Section 106A of the Town and Country Planning Act 1990

Application No: WA/32/26/DOV
Site Address: Land East of Tye Lane Walberton
Description of works: Request to enter into a Deed of Variation to modify a Planning Obligation dated 18th November 2017 relating to planning application WA/44/17/OUT to modify clause 2.9 to include new definitions and modify definition of public open space. New clause 31 to be added dealing with the transfer of the Play Areas to the Parish Council and new clause 32 dealing with the transfer of the Allotments to the Parish Council. New Appendix 3 to be added to append the Appendix 3 Estate Plan showing the Allotments and Play Areas.

Thank you for your internet representation made on 5th May 2026 which has been recorded as an objection with the comments as follows:

Drawing Title			
COMBINED ESTATE PLAN			
D Scale 1:1000	Date 21.11.19	Designed by MJR	
Drawn by MJR	Checked by JM	Approved by -	
Drawing Number LHS240-5202			Rev P14

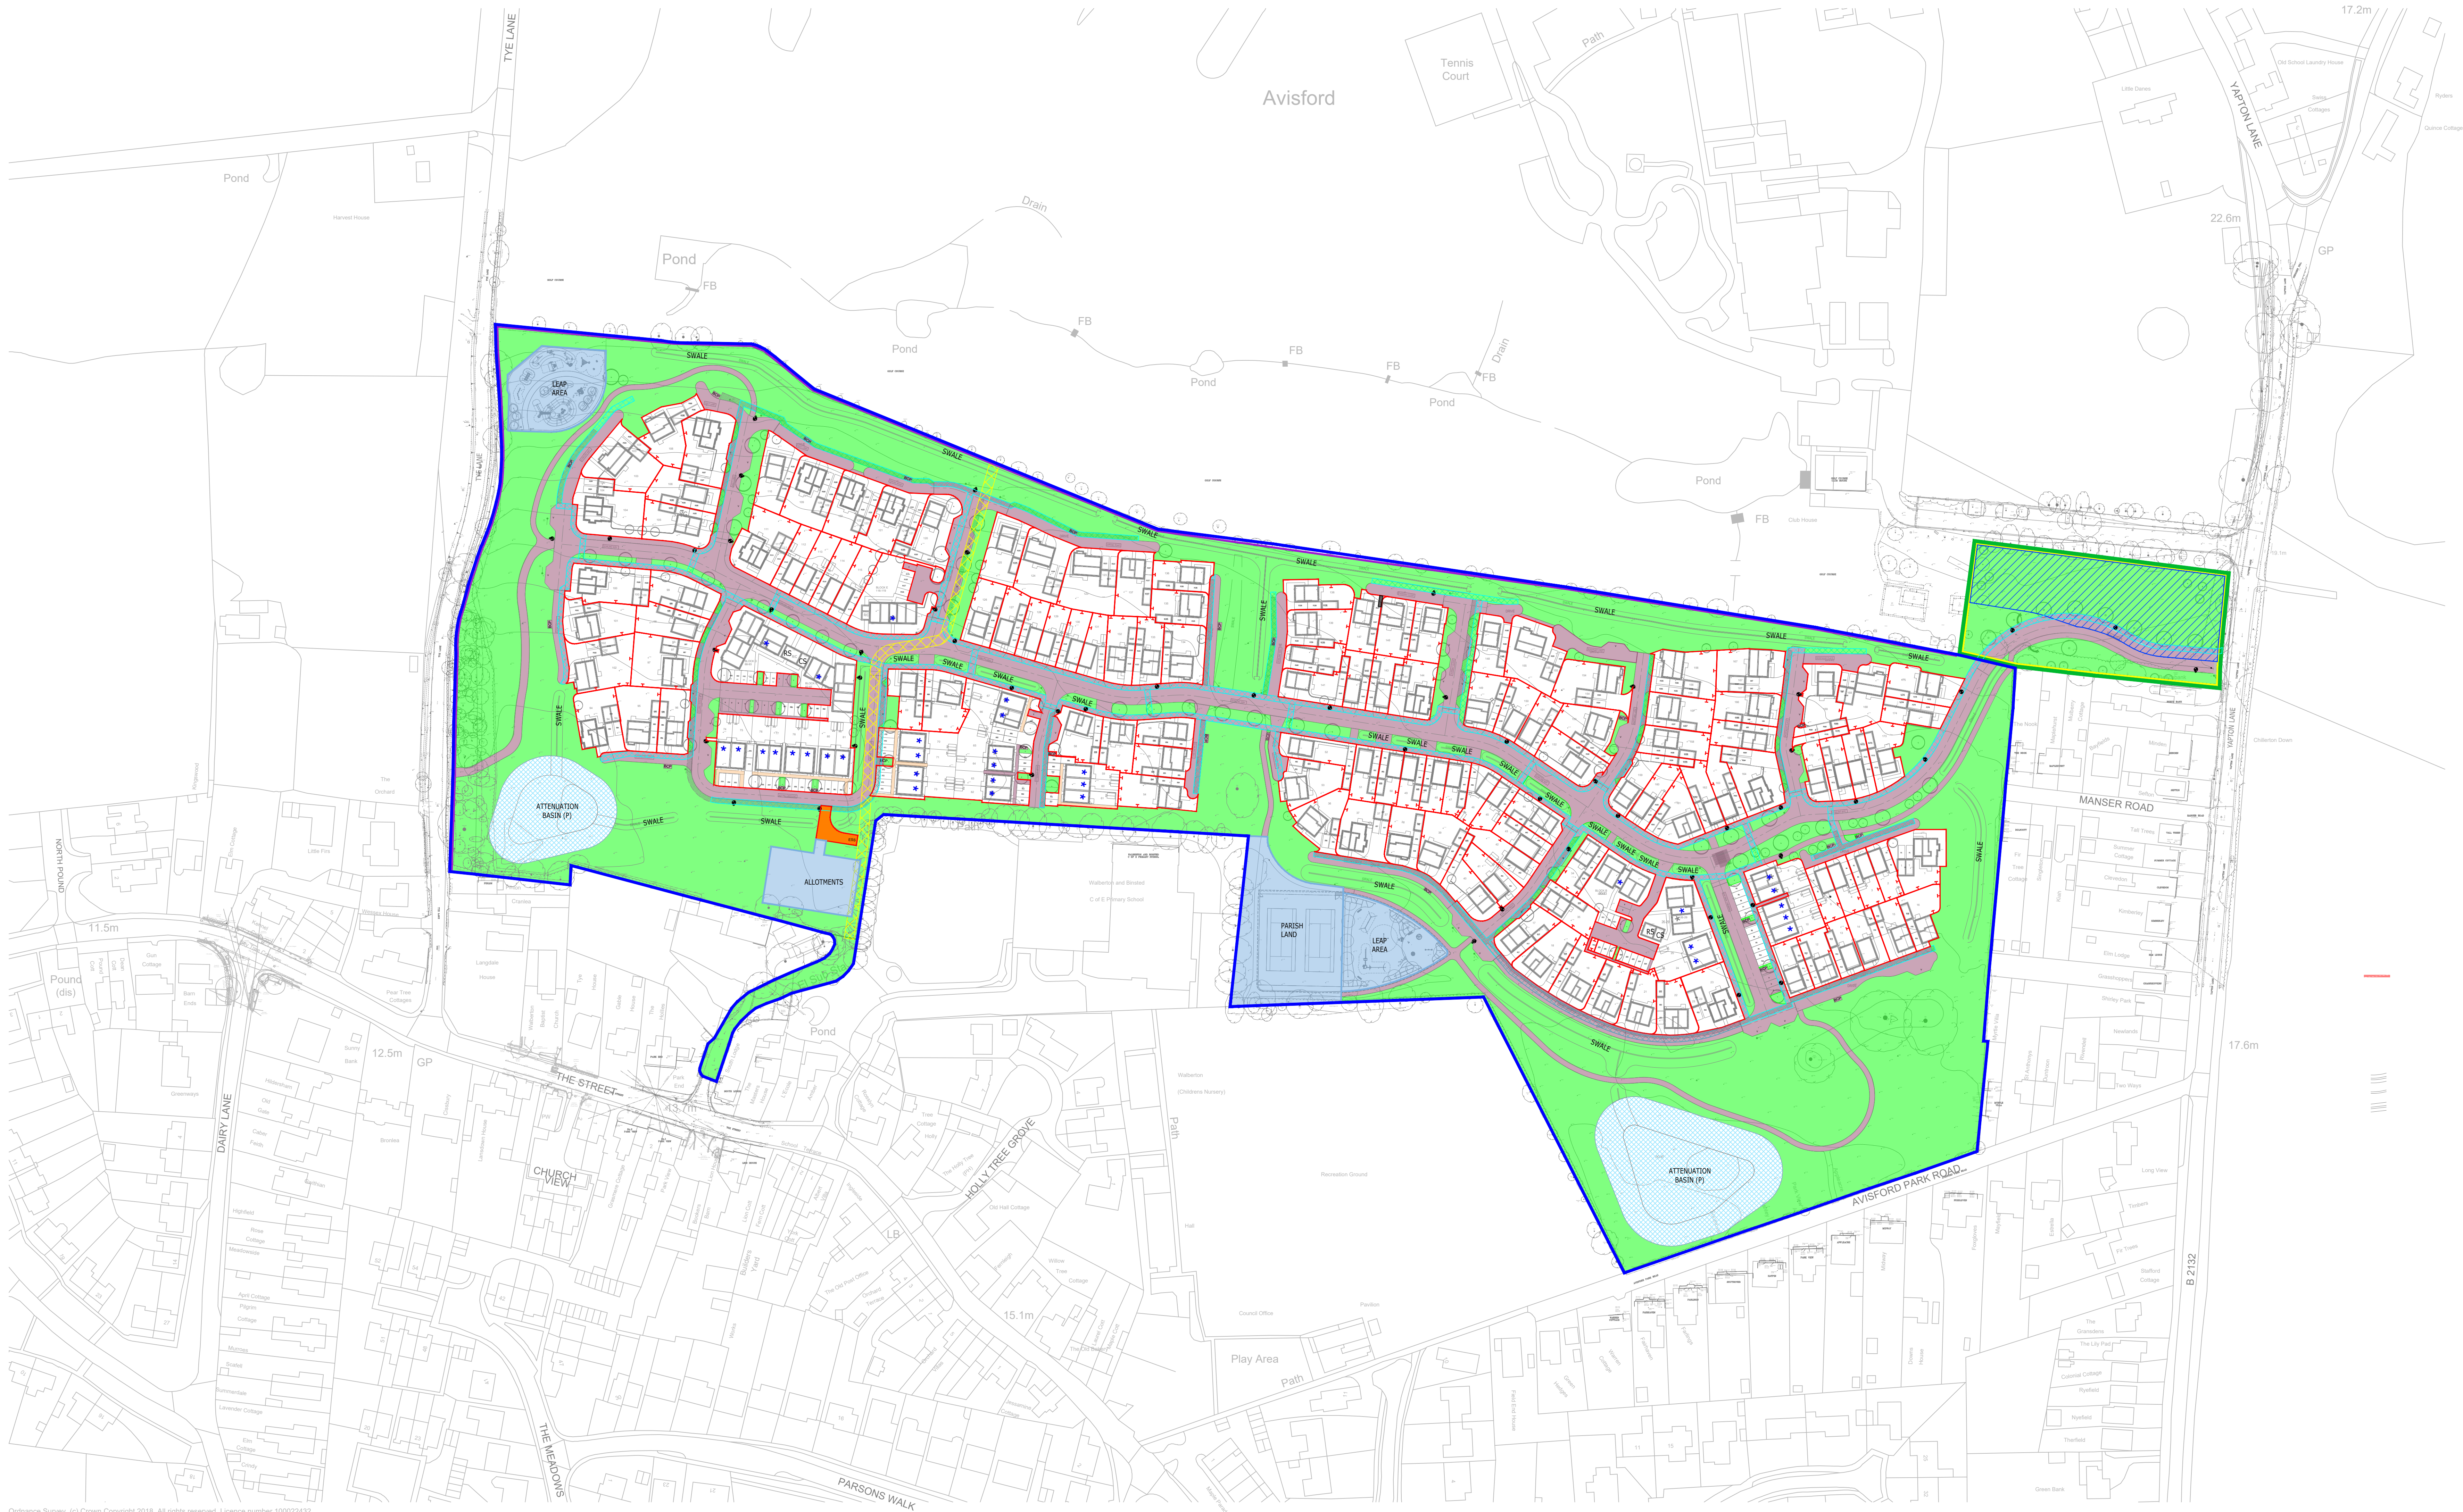
A standard allotment is classified as 250 square metres.
This allotment area only has THREE half standard size (125 sq m) allotments and space for car parking.

I cannot see any provision of water or a water meter. Has this already been addressed and installed?

Boundary - I note the following landscape proposals on WA/94/19/NMA
Public open space landscape proposals sheet 1 of 4 107 Rev M

Will Linden be providing and maintaining all landscaping i.e. native hedgerow mix on their land?

Post and rail fence - this has already been installed. Is this on Linden land? If so Linden will be maintaining.

Timber field gate to access car park - Linden has fitted a double, not single as per landscape plan, gate.

Should Linden not be supplying and maintaining the boundary then Walberton Parish will be involved in considerable extra costs for only 3 half size plots when there is still availability at Fontwell Meadows.

Play areas - LEAP

These 2 LEAPs will require regular visits, substantial costs for mowing and vegetation, ongoing repairs and maintenance.

I would not be surprised to see this amount doubled for each of the 2 LEAPs at Avisford Grange. Approximately £32,000 in total per annum and do not consider this should be paid out of our council tax.
